18 March 2021

TfNSW Reference: SYD19/00495/06
DPIE Reference: SSD 10291

REVIEW OF UPDATED TRAFFIC ADVICE FOR ST LUKES GRAMMAR SCHOOL SENIOR SCHOOL CAMPUS AND SPORTS CENTRE - 210 HEADLAND ROAD, DEE WHY

Plan View b - Driveway Line of Sight - plan view - **REVISED LANDSCAPING WALLS**

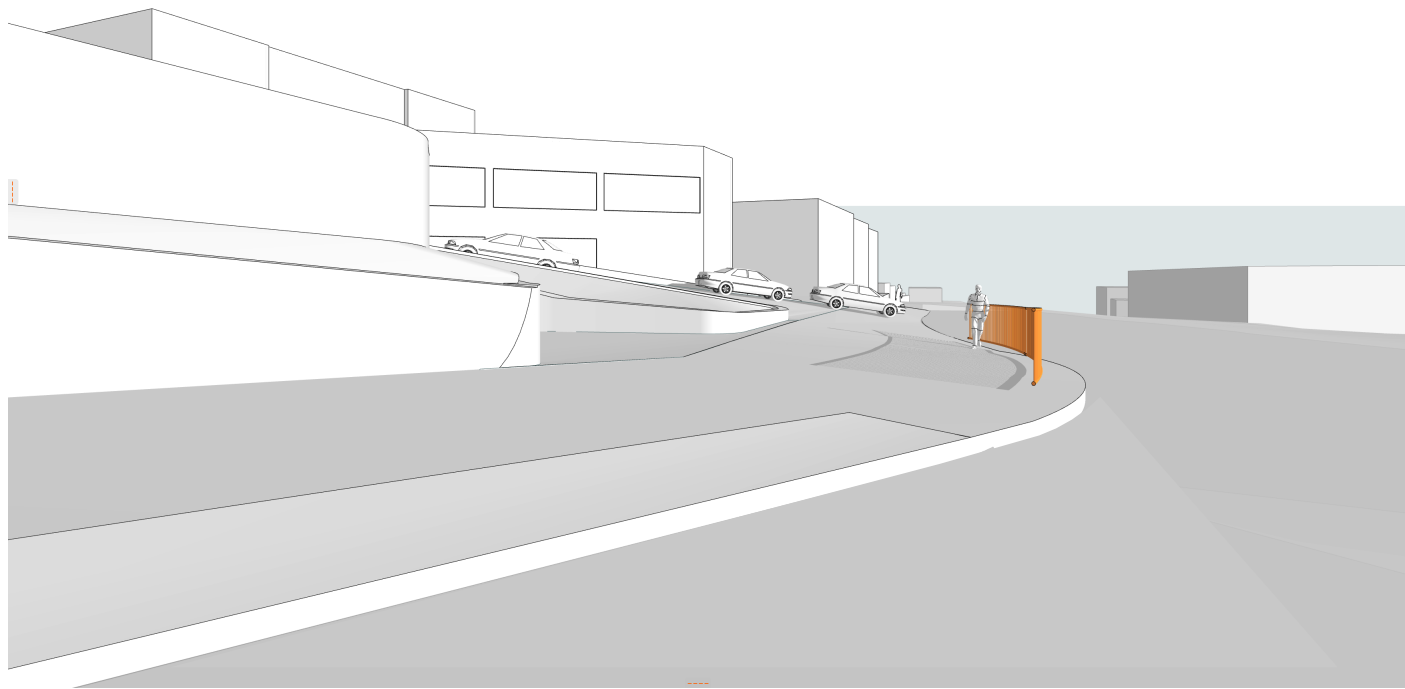
TfNSW notes that the provision of a pedestrian fence may obstruct line of sight for vehicle turning left from Pittwater Road and vehicle departing from the driveway. A line of sight assessment should be undertaken for the proposed pedestrian fence.

View 02b - Pedestrian Fence Line of Sight - approaching from West (from Warringah Road) - **REVISED LANDSCAPING WALLS**

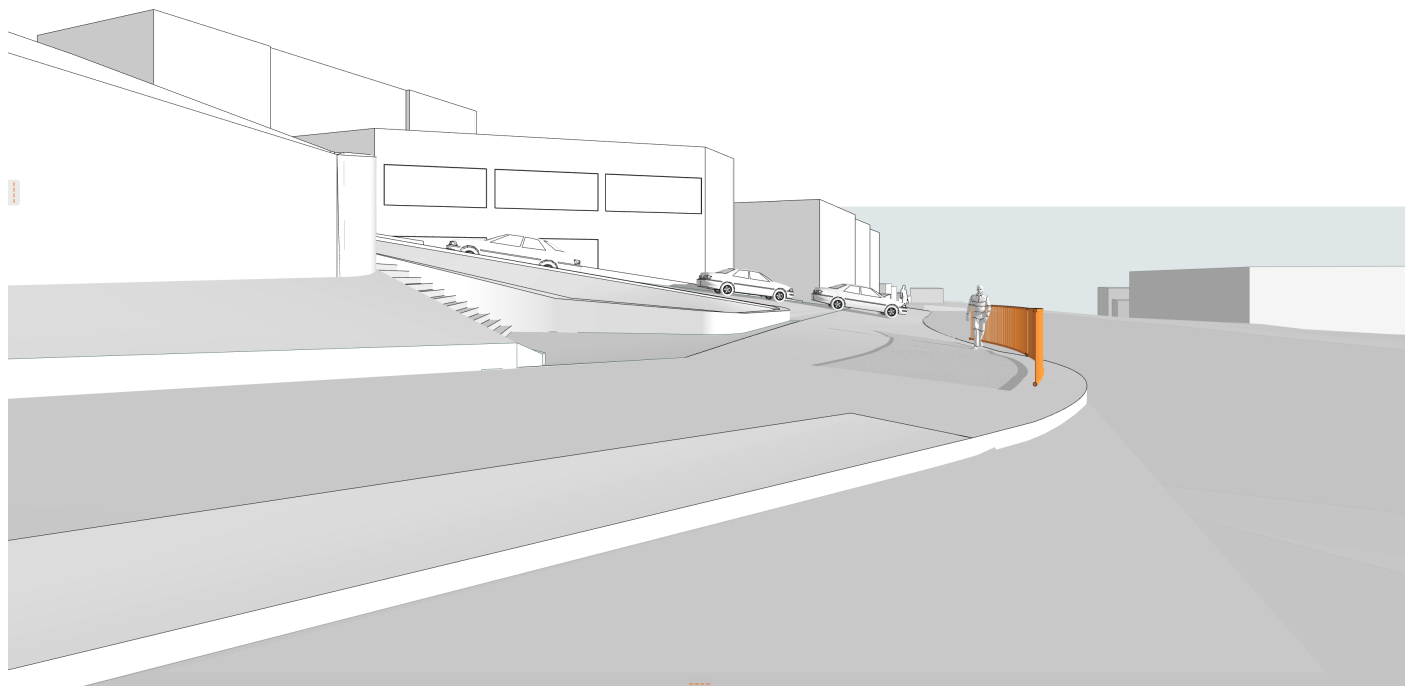
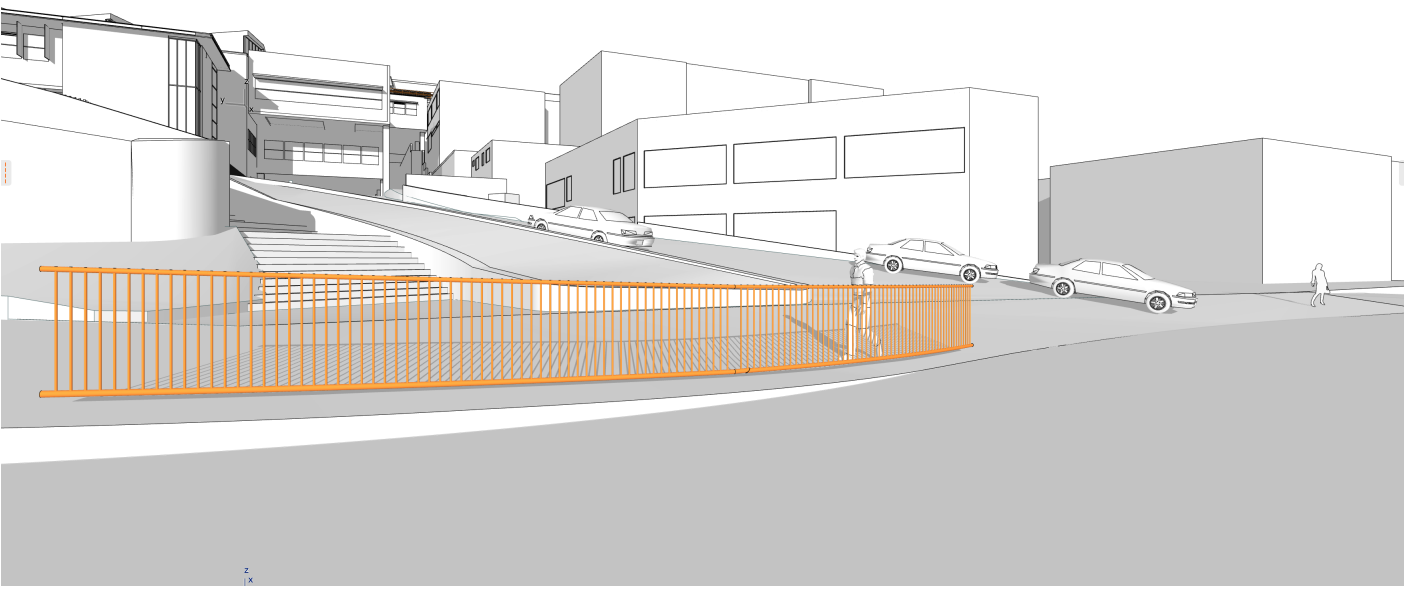
13. The RtS states that a pedestrian fence is proposed along the kerb line at the north-east corner of Pittwater Road/Warringah Road intersection
